# SUNNICA ENERGY FARM

8.112 The Applicant's position on 'parcel by parcel' mitigation and residual effects

<b>Planning Inspectorate Scheme Reference</b>	EN010106
<b>Application Document Reference</b>	EN010106/APP/8.112
<b>Author</b>	Sunnica Energy Farm Project Team

<b>Version</b>	<b>Date</b>	<b>Status of Version</b>
Rev 00	13 March 2023	Deadline 8 Submission

Drawing Title  
**FIGURE 10-14C  
 LANDSCAPE MASTERPLAN  
 SUNNICA EAST SITE B**

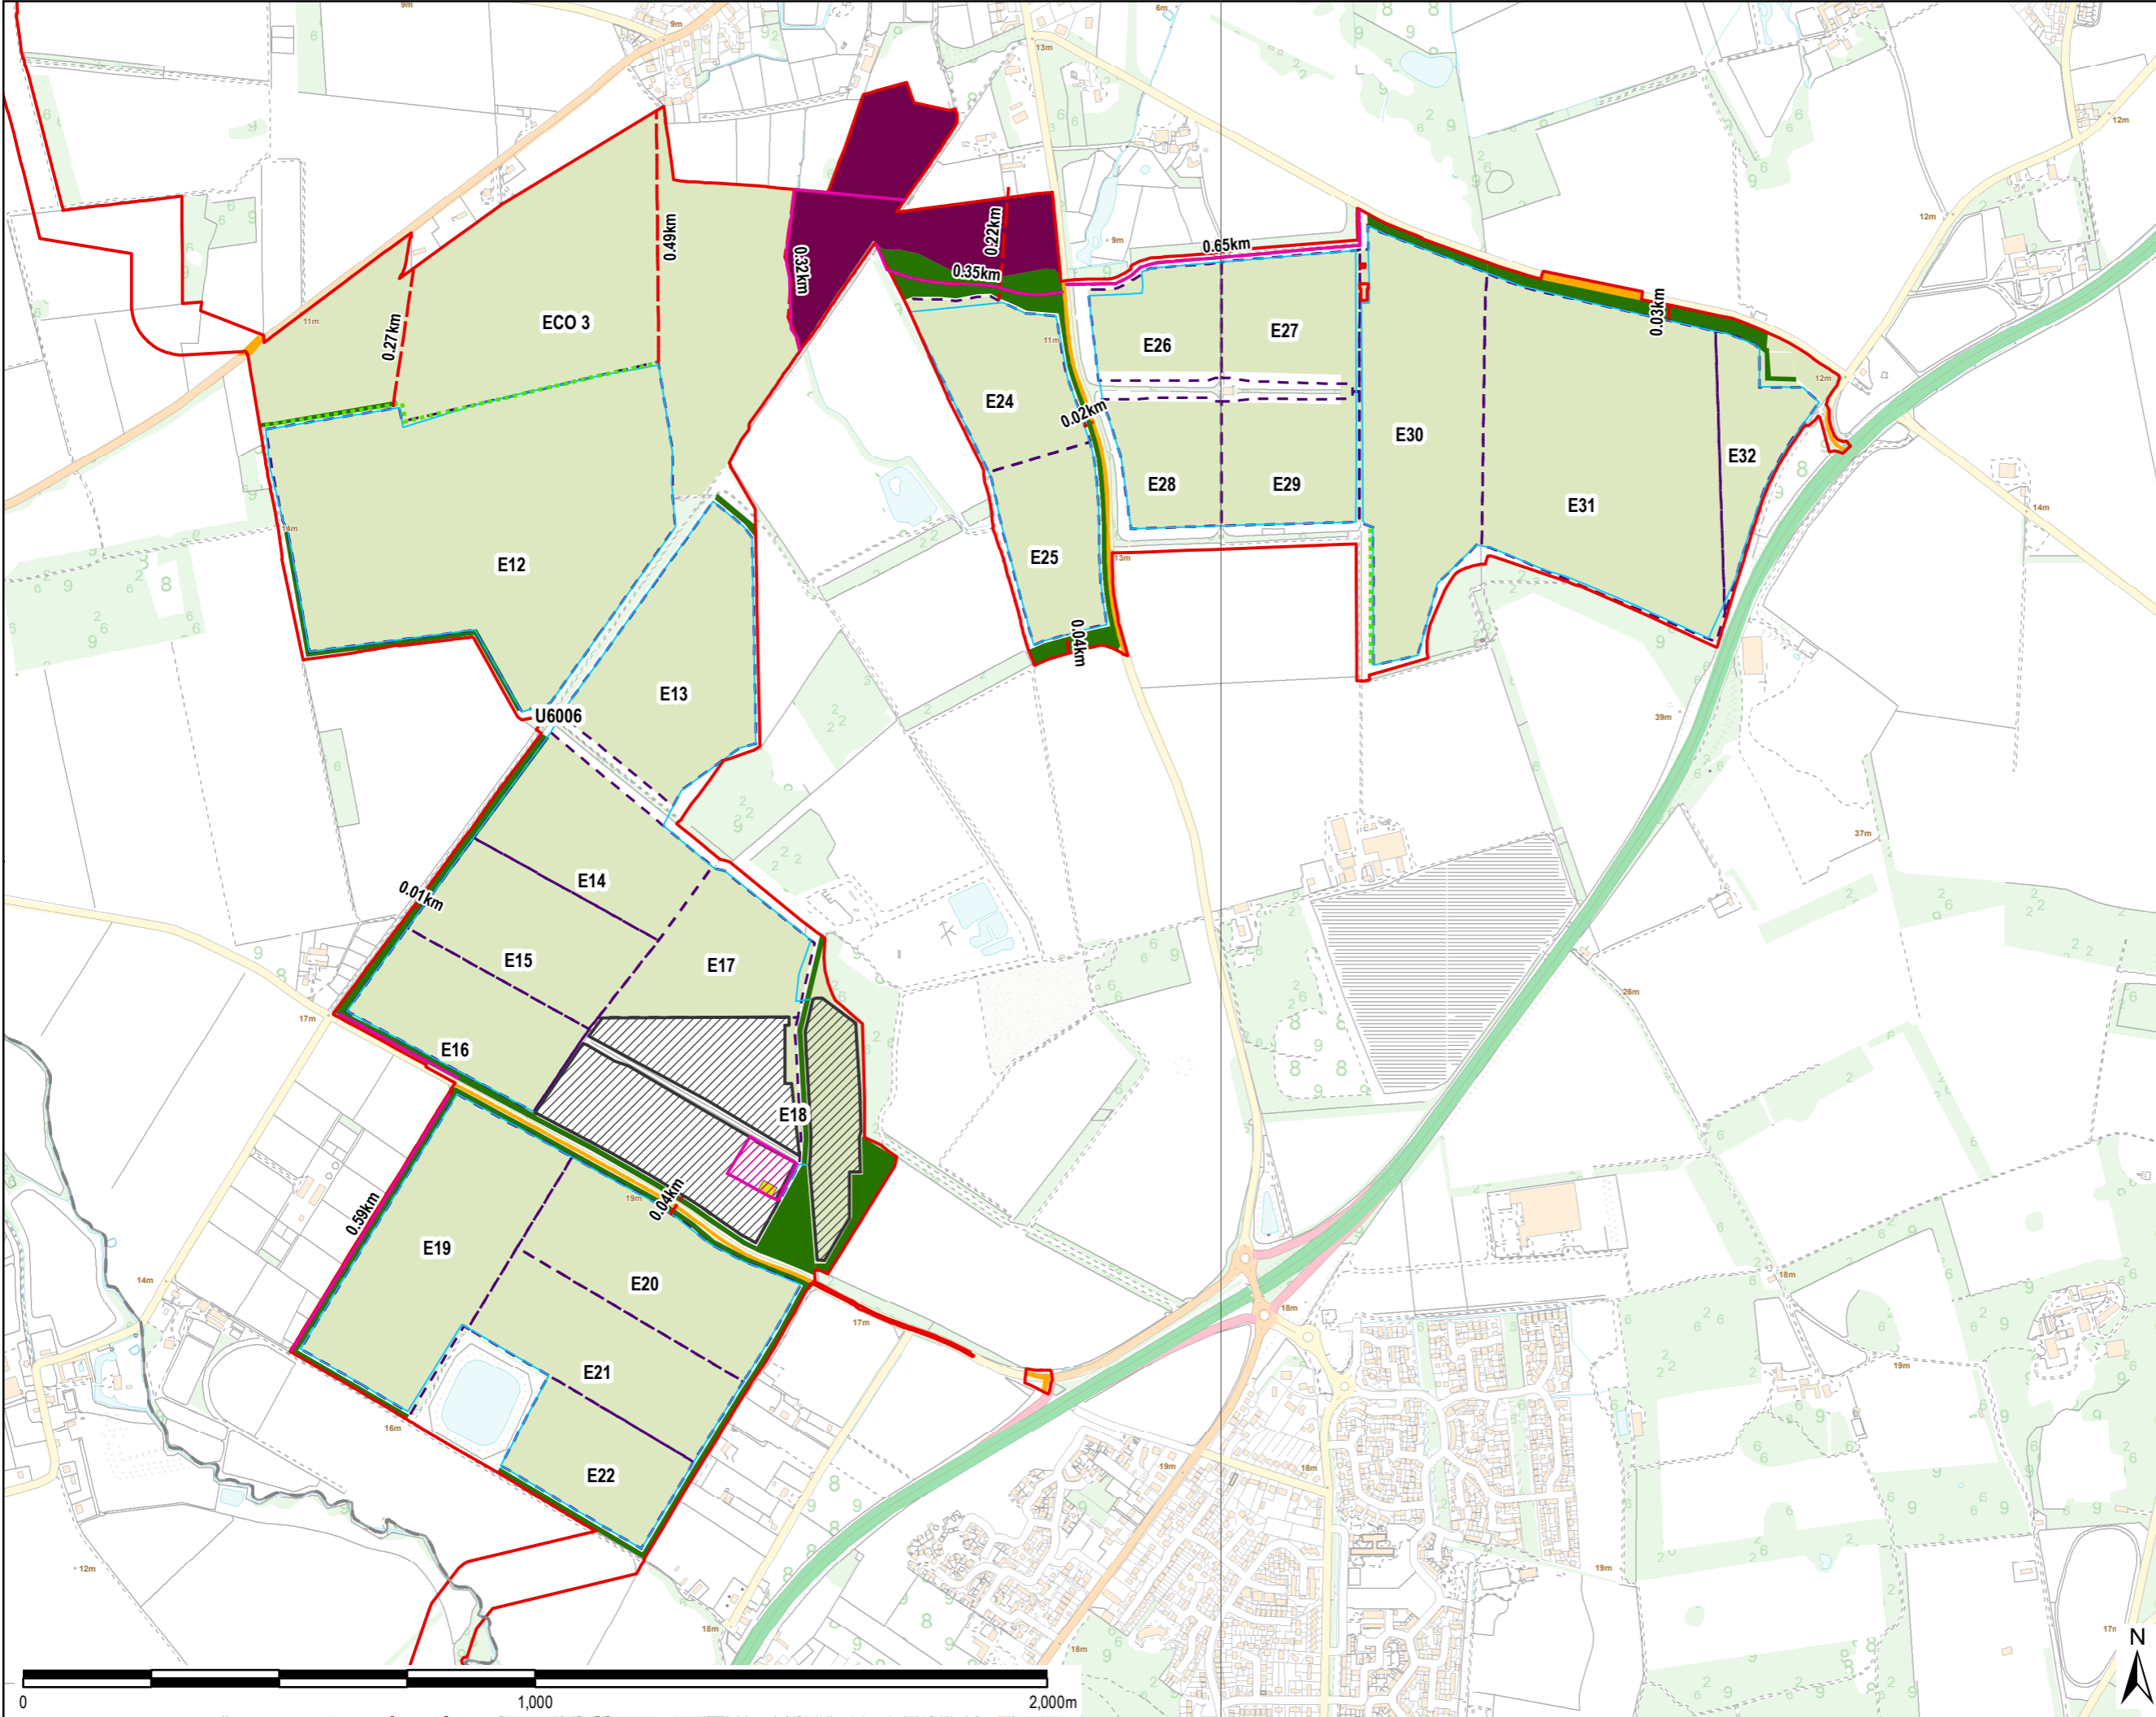
<b>E16</b>	<ul style="list-style-type: none"> <li>– solar panels have been offset from the intervening pine lines</li> </ul>	<ul style="list-style-type: none"> <li>- views to the BESS from the U6006 would</li> </ul>	<p>Being sensitive to the existing landscape structure...</p>	-	<ul style="list-style-type: none"> <li>-BESS and substation and panels in E16 would remain visible</li> </ul>	<p>Notes have been added to the added to the Environmental</p>

E17	<ul style="list-style-type: none"> <li>-proposed tree belt to the east (shown on EnvM)</li> </ul>	<ul style="list-style-type: none"> <li>-open views of BESS and substation at E18 particularly relevant if offsite woodland is removed or thinned in the future.</li> </ul>	<p>Being sensitive to the existing landscape structure...</p> <ul style="list-style-type: none"> <li>- repair and strengthen the pine line on north-western boundary</li> <li>-provide tree belt along southern boundary of E17 with E18 to improve screening of BESS.</li> </ul>	-	<ul style="list-style-type: none"> <li>-BESS and substation would remain visible initially but effects would reduce as vegetation matures</li> </ul>	<p>A pine line with a shrub understorey and a width of 10m is proposed along the southern edge. Interplanting will strengthen existing screening to the west. E17 is internal to the site and will be screened by 25m width of woodland along Elms Road and earthworks and</p>

<b>E19</b>	<p>– The solar panels have been located to reflect the landscape pattern and retain the intervening pine lines.</p> <p>-New woodland proposed on the</p>	<p>-Panels visible from the existing PRoW to the south of E19 and close to the reservoir</p> <p>-Panels prominent from the permissive path on the northwest boundary of E19</p>	<p>-plant a tree belt to reinforce the planting along Elms Road</p> <p>-Water reservoir: Plant up the triangular area on the south-western side of the reservoir within parcel E19</p>	-review screening around reservoir between E22 and E19 and consider hedgerow planting in corners adjacent to the reservoir	-Initially the panels would remain visible from the existing PRoW to the south of E22, particularly through gaps and close to the reservoir however this would	A pine line with a shrub understorey is proposed along the western boundary with a width of 25m to reinforce screening from the adjacent permissive path and

<b>E20</b>	-The solar panels have been located to reflect the landscape pattern and retain the intervening pine lines. -New woodland is proposed around the eastern and north-eastern perimeter of the parcel to reduce	-Multiple barriers between the traveller's site and the scheme unlikely to give cohesive approach -Proposed additional planting welcomed but unlikely to screen the proposals effectively -Woodland planting on both sides of Elms	-Strengthen internal treelines between E20, E19 and E21 (see VP 20). -On the eastern side of the parcel increase buffer between fence and solar panels to 30m and provide tree belt with hedgerows on	-Applicant proposes to increase the width of planting along the eastern edge of E20 to 15m to screen views from residents adjacent to Bridge End Road (not yet shown on EnvM)	-Initially the panels would remain visible to the residents on the traveller's site however this would reduce to an acceptable level as vegetation matures. - Loss of view for the neighbouring residents would remain	Notes have been added to the Environmental Masterplans [REP7-054] and OLEMP [REP7-015] to explain that existing pine lines on the boundaries between parcels will be strengthened through interplanting. Linear

<b>E21</b>	-The solar panels have been located to reflect the landscape pattern and retain the intervening pine lines. -New woodland is proposed on the south-eastern boundary to reduce the visibility from residents adjacent to Bridge End Road.	-Infrastructure visible from businesses on Bridge End Road	-Strengthen internal treelines between E20, E19 E21 and E22 (see VP 20). -Extend the 30m enhanced planting requested on the eastern side of E20	-	-Initially the panels would remain visible from businesses on Bridge End Road but would reduce to an acceptable level as the vegetation matures	Notes have been added to the Environmental Masterplans [REP7-054] and OLEMP [REP7-015] to explain that existing pine lines on the boundaries between parcels will be strengthened through interplanting. Linear belts of trees and shrubs to east will be 15m wide.  The distance between the site boundary and proposed solar panel

<b>E24</b>	<ul style="list-style-type: none"> <li>– New woodland planting is proposed to the north, and east of the parcel to screen the structures and reduce the perception of the scheme when travelling along Worlington Road;</li> </ul>	<ul style="list-style-type: none"> <li>-Long distance views from U6006 across landscape to panels would remain</li> <li>-potential visual effects around the access from Worlington Road into</li> </ul>	<ul style="list-style-type: none"> <li>-Provide appropriate screen planting along western boundary of the parcel, incl. hedges and pines to screen these parcels to views from the U6006.</li> </ul>	<ul style="list-style-type: none"> <li>-Applicant has stated that they have reviewed this suggested change, there is an existing bund and vegetation, but no further planting can be accommodated</li> </ul>	<ul style="list-style-type: none"> <li>-Initially long-distance views from U6006 across landscape to panels would remain however these would reduce to an acceptable level as vegetation matures</li> </ul>	<ul style="list-style-type: none"> <li>This was reviewed on site. There is existing vegetation in the northern part, which will be retained. Earthworks extend along the boundary and preclude additional planting. Intervening</li> </ul>

<b>E26- E27</b>	-Panels are offset from the boundary vegetation.	-Views across the rear of the panels from permitted path to the north will remain	-Consider a hedgerow to soften the impact of the panels when viewed from the path	-Path running along northern edge of E26 and E27, considering the addition of a hedgerow.	-Panels would be visible initially but as vegetation matures it would provide screening	An additional hedgerow along the northern edge of E26 would enclose permissive path and reduce natural surveillance and cannot be accommodated in this location. Interpretation boards added at key intersections of the permissive paths and

<b>E32</b>	<ul style="list-style-type: none"> <li>– The woodland in the south-east part of the Site has been retained.</li> <li>-Additional hedgerow and woodland planting are proposed adjacent to a short section of Golf Links Road (30m)</li> </ul>	<ul style="list-style-type: none"> <li>-Unknown impact on vegetation to form access I off the A11</li> <li>-Unacceptable views of vast expanse of solar panels for motorists on the corner of Golf Links Road on the home stretch to Worlington.</li> <li>-Views from the wider landscape to the north,</li> </ul>	<ul style="list-style-type: none"> <li>-Plant up entire north-eastern corner (outside developable area) of E32 with woodland including oaks (see VP26A) avoiding archaeological constraints and access visibility splays to screen views of the panels and provide a</li> </ul>	<ul style="list-style-type: none"> <li>-Review screening in this location and move proposed planting away from the barrow.</li> <li>-Applicant to provide further detail on design and transport constraints on screening at this location.</li> </ul>	<ul style="list-style-type: none"> <li>-Unknown impact on vegetation to form access I off A11</li> <li>-Initial views of vast expanse of solar panels would reduce as vegetation matures</li> <li>-Views from the wider landscape to the north</li> </ul>	<p>The design has been amended to work around the archaeological constraints in the corner of E32, comprising and hedgerow with trees. Views into this part of the site from the road</p>

Ref.	Current proposals as detailed in OLEMP [REP5-014]	Residual effects	Further mitigation required [REP4-149] and LIR [REP1-024]	Applicants mitigation under discussion/or not yet shown on EnvM –[AS-324] and/or [AS-321]	Residual effects if the Council's mitigation is implemented in full	Applicant's response at Deadline 8
	<ul style="list-style-type: none"> <li>-panels have also been offset from U6006</li> <li>-Increased width of planting to 15m along the western edge of E14 to E16 to further screen views from U6006 [AS-321]</li> </ul>	<ul style="list-style-type: none"> <li>remain particularly in winter</li> <li>-views of panels within E16 from the U6006 and from Elms Road initially and then in winter would remain including through access points</li> <li>-truncation of views to the east from the U6006 particularly in summer</li> <li>-views of the BESS from the wider countryside would remain</li> </ul>	<ul style="list-style-type: none"> <li>-reinforce pine lines/tree belts along the southern edge (see VP15B VP21, VP21A).</li> <li>-strengthen the boundary between this parcel and E15 by planting additional pines.</li> <li>-Along eastern boundary repair and strengthen the pine line.</li> <li>-reinforce pine lines/tree belts along the western boundary.</li> </ul>		<ul style="list-style-type: none"> <li>initially but effects would reduce to an acceptable level as vegetation matures aided by the strengthening of treelines</li> <li>-truncation of views to the east from the U6006 particularly in summer</li> </ul>	<p>Masterplans [REP7-054] and OLEMP [REP7-015] to explain that existing pine lines on the boundaries between parcels will be strengthened through interplanting.</p> <p>A linear belt of trees and shrubs along the southern boundary (15m wide) linking with pine lines with a shrub understorey on the western boundary (15m wide) will fulfil the screening function requested.</p>

Ref.	Current proposals as detailed in OLEMP [REP5-014]	Residual effects	Further mitigation required [REP4-149] and LIR [REP1-024]	Applicants mitigation under discussion/or not yet shown on EnvM –[AS-324] and/or [AS-321]	Residual effects if the Council's mitigation is implemented in full	Applicant's response at Deadline 8
						existing woodland to the north and east. A linear belt of trees and shrubs with a width of 25m is proposed to the north of Elms Road to reinforce screening an enclosure provided by the existing hedgerow. Internal field boundaries between parcels will be strengthened through inter-planting and natural regeneration [REP7-054]
<b>E18</b>	<p>Siting the BESS and substation in E18 so that it is enclosed and screened by existing woodland along its northern edges and in part by roadside vegetation adjacent to Elms Road to its south-east.</p> <p>-Increased width of planting along the edge of E18 to 25m</p> <p>-The tonal rendering of shades which are</p>	<p>-visual effects of proposed BESS prominent from Elms Road in particular in winter and from the west in the wider landscape</p> <p>-BESS would remain visible in the wider landscape from the north and the west particularly relevant if offsite woodland is removed in the future.</p>	<p>-Provide tree belt along southern boundary of E17 towards BESS in E18. (see VP16)</p> <p>-strengthen tree belts within parcels 14- 17 to provide layers of landscape screening</p> <p>-re-instate any hedgerows removed behind the visibility splays.</p> <p>-Environmental colour Assessment to be undertaken at detailed</p>	-	<p>-The BESS and other solar infrastructure would remain visible and incongruent in the landscape initially including from the U6006 and the wider landscape to the north and west and from Elms Road, although the effects would be tempered by the tonal rendering of shades of structures.</p>	<p>A linear belt of trees and shrubs with a width of 25m is proposed to the north of Elms Road to reinforce screening and enclosure provided by the existing hedgerow. Internal field boundaries between parcels will be strengthened through inter-planting and natural regeneration [REP7-054].</p>

Ref.	Current proposals as detailed in OLEMP [REP5-014]	Residual effects	Further mitigation required [REP4-149] and LIR [REP1-024]	Applicants mitigation under discussion/or not yet shown on EnvM –[AS-324] and/or [AS-321]	Residual effects if the Council's mitigation is implemented in full	Applicant's response at Deadline 8
	northwest and southwest around perimeter of the parcel to reduce the visibility from the PRoW, as well as screen the structures and reduce the perception of the Scheme from Badlingham;	-Woodland planting on both sides of Elms Road significantly changes character	(Locations for tree groups?) -Strengthen internal treelines between E19, E20 and E21 (see VP 20). -careful design of permissive path required to retain privacy of adjacent landowner		reduce to an acceptable level as vegetation matures. -The panels would be prominent from the permissive path on the northwest boundary of E19 but as the vegetation matures the amenity of the footpath would improve particularly if it were located within the woodland belt. -Woodland planting on both sides of Elms Road significantly changes character	Brooklands stud. Belts of trees and shrubs are also proposed to strengthen existing vegetation to the north and south with a width of 10m. Internal boundaries will be strengthened through inter-planting and natural regeneration. Planting the corners of the reservoir would prevent safe access to the reservoir and cannot be accommodated here. The existing hedgerow to the south provides effective screening. [REP7-054]

Ref.	Current proposals as detailed in OLEMP [REP5-014]	Residual effects	Further mitigation required [REP4-149] and LIR [REP1-024]	Applicants mitigation under discussion/or not yet shown on EnvM –[AS-324] and/or [AS-321]	Residual effects if the Council's mitigation is implemented in full	Applicant's response at Deadline 8
	the visibility from residents adjacent to Bridge End Road.	Road significantly changes character -Loss of view for the neighbouring residents -Woodland planting on both sides of Elms Road significantly changes character	either side for visual amenity purposes.		-Woodland planting on both sides of Elms Road significantly changes character	belts of trees and shrubs to the north will be 10m and to the east will be 15m wide. A timber closed boarded fence will also line the eastern boundary to screen views from the adjacent travellers' site.  The distance between the site boundary and proposed solar panel arrays is 30m or greater in this location.

Ref.	Current proposals as detailed in OLEMP [REP5-014]	Residual effects	Further mitigation required [REP4-149] and LIR [REP1-024]	Applicants mitigation under discussion/or not yet shown on EnvM –[AS-324] and/or [AS-321]	Residual effects if the Council's mitigation is implemented in full	Applicant's response at Deadline 8
						arrays is 30m or greater in this location.
<b>E22</b>	<ul style="list-style-type: none"> <li>-The solar panels have been located to reflect the landscape pattern and retain the intervening pine lines.</li> <li>-New woodland is proposed around the eastern and southwestern boundary of the parcel to reduce the visibility from businesses adjacent to Bridge End Road and local PRow.</li> </ul>	<ul style="list-style-type: none"> <li>-Panels visible from the existing PRow to the south of E22, particularly through gaps and close to the reservoir</li> <li>-Infrastructure visible from businesses on Bridge End Road</li> </ul>	<ul style="list-style-type: none"> <li>-Water reservoir: Plant up the triangular area on the south-eastern side of the reservoir within parcel E22 extending along the boundary with the reservoir as necessary. (Locations for tree groups?)</li> <li>-Strengthen internal treelines between E22, E21.</li> <li>-Extend the 30m enhanced planting requested on the eastern side of E20 and E21</li> </ul>	<ul style="list-style-type: none"> <li>-Review screening around reservoir between E22 and E19 and consider hedgerow planting in corners adjacent to the reservoir</li> </ul>	<ul style="list-style-type: none"> <li>-Initially the panels would remain visible from the existing PRow to the south of E22, particularly through gaps and close to the reservoir however this would reduce to an acceptable level as vegetation matures.</li> <li>-Effects would also reduce to an acceptable level in relation to Bridge end road as the vegetation matures</li> </ul>	<ul style="list-style-type: none"> <li>Planting the corners of the reservoir would prevent safe access to the reservoir and cannot be accommodated here. The existing hedgerow to the south provides effective screening and will be strengthened through tree and shrub planting with a width of 10m, as shown on the Environmental Masterplans [REP7-054]</li> <li>The distance between the site boundary and proposed solar panel arrays is 30m or greater in this location.</li> </ul>

Ref.	Current proposals as detailed in OLEMP [REP5-014]	Residual effects	Further mitigation required [REP4-149] and LIR [REP1-024]	Applicants mitigation under discussion/or not yet shown on EnvM –[AS-324] and/or [AS-321]	Residual effects if the Council's mitigation is implemented in full	Applicant's response at Deadline 8
		the parcels would remain -unacceptable loss of TPO trees for cable crossing of U6006 north of E24	-Identify access points on Environmental Masterplan.	due to space constraints.		vegetation provides an effective screen in views from the U6006.
<b>E25</b>	-New woodland planting is proposed to the east and south of the parcel to screen the structures and reduce the perception of the scheme when travelling along Worlington Road;	-Long distance views from U6006 across landscape to panels would remain -Potential visual effects around the entrance from Worlington Road into the parcels would remain	-Provide appropriate screen planting along western boundary of these parcels, incl. hedges and pines to screen these parcels to views from the U6006. -Identify access points on Environmental Masterplan.	-Applicant has stated that they have reviewed this suggested change, there is an existing bund and vegetation, but no further planting can be accommodated due to space constraints.	- Initially long-distance views from U6006 across landscape to panels would remain however these would reduce to an acceptable level as vegetation matures	This was reviewed on site. There is existing vegetation in the northern part, which will be retained. Earthworks extend along the boundary and preclude additional planting. Intervening vegetation provides an effective screen in views from the U6006.

Ref.	Current proposals as detailed in OLEMP [REP5-014]	Residual effects	Further mitigation required [REP4-149] and LIR [REP1-024]	Applicants mitigation under discussion/or not yet shown on EnvM –[AS-324] and/or [AS-321]	Residual effects if the Council's mitigation is implemented in full	Applicant's response at Deadline 8
						local road network to enhance wayfinding and legibility [REP7-054].
<b>E28-E29</b>	-Panels offset from the boundary vegetation.	-views of solar infrastructure in winter through porous tree screen/woodland	- Additional hedge should be included between the DCO limits and the track along the south of E28 and E29.	-	-	There is already dense vegetation along the southern edge of E28 and E29 and an additional hedgerow provides no additional benefit to screening [REP7-054].
<b>E30</b>	<p>– The woodland in the south-east part of the Site has been retained.</p> <p>-Additional hedgerow and woodland planting are proposed adjacent to Golf Links Road (30m)</p> <p>-Woodland to the north of the parcel and east of the existing access to be retained and planting in gaps in vegetation on northern edge</p>	<p>-Views of vast expanse of solar panels for motorists on Golf links road (VP24) through existing gaps and entrances initially</p> <p>-Perception of the Scheme in relation to Worlington.</p>	<p>-Additional hedges along the western boundary of E30.</p> <p>-Remove security fence from the retained woodland</p> <p>-Strengthen hedge between E30 and E31 as required.</p>	-	-Initially vast extent of panels across E30 would persist however this would reduce as vegetation matures (VP24)	<p>The design of the Scheme has been altered to retain the existing recent tree and shrub planting at the site entrance. Fully planting up this gap is not possible due to access requirements for the Scheme and the permissive path.</p> <p>A substantial belt of tall evergreen trees lines the boundary between E30 and E31. No additional planting is required [REP7-054].</p>

Ref.	Current proposals as detailed in OLEMP [REP5-014]	Residual effects	Further mitigation required [REP4-149] and LIR [REP1-024]	Applicants mitigation under discussion/or not yet shown on EnvM –[AS-324] and/or [AS-321]	Residual effects if the Council's mitigation is implemented in full	Applicant's response at Deadline 8
		persisting into the long-term.	positive focus on this corner. -Provide more robust planting along the south-eastern edge of E32 and provide screening of solar panels at access.		would reduce as vegetation matures.	and filtered by existing vegetation [REP7-054].
